KITTITAS COUNTY

DEPARTMENT OF PUBLIC WORKS

MEMORANDUM

TO: All Staff
FROM: Public Works Plan Review Team
DATE: September 28th, 2023
SUBJECT: BL-23-00021 Hutchinson

PART OF SECTIONS 2 & 11, TOWNSHIP 18 NORTH, RANGE 17 EAST, W.M.

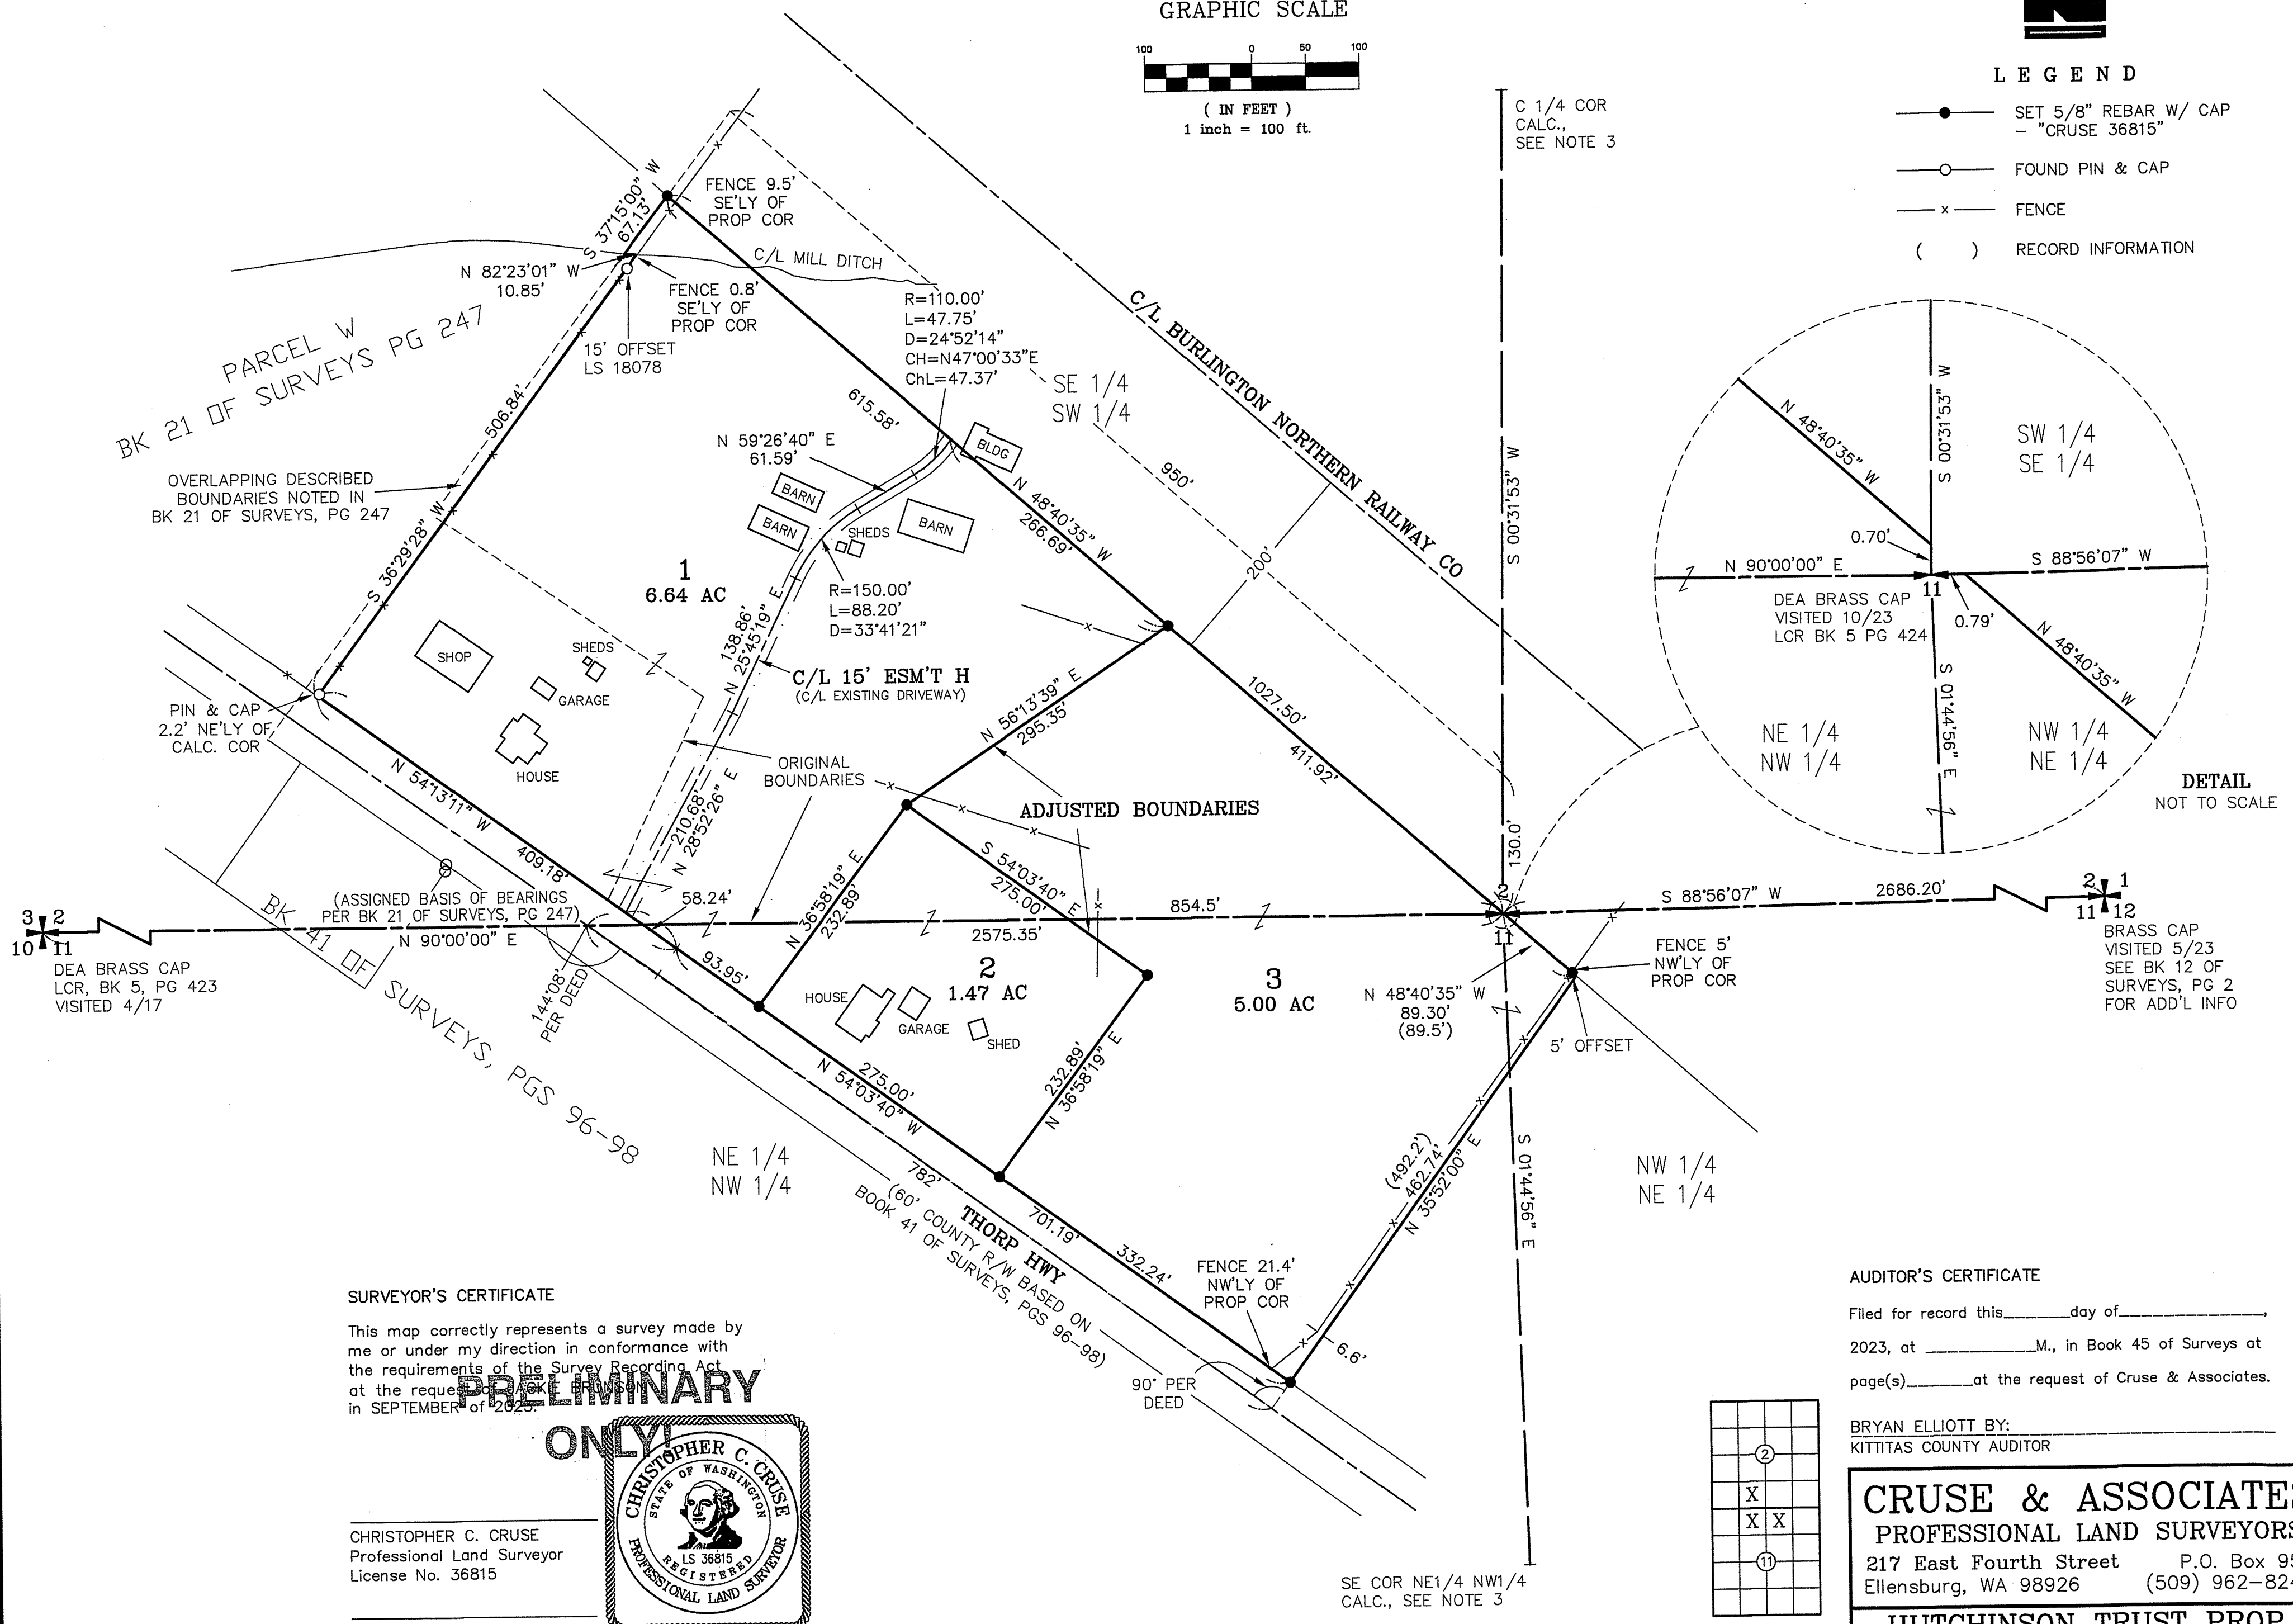
SURVEY	<p>As the application does not contain a survey map, survey reviewed is reserved until final submittal. (JT)</p> <p>UPDATE 11/17/2023</p> <ol style="list-style-type: none">1. Please put the deflection angles per deed in brackets to show they are record data, and that observed values may differ. This is in regards to the "144°08' PER DEED" and "90° PER DEED" notes located at the centerline of Thorp Highway.
TRANSPORTATION CONCURRENCY	No Comments
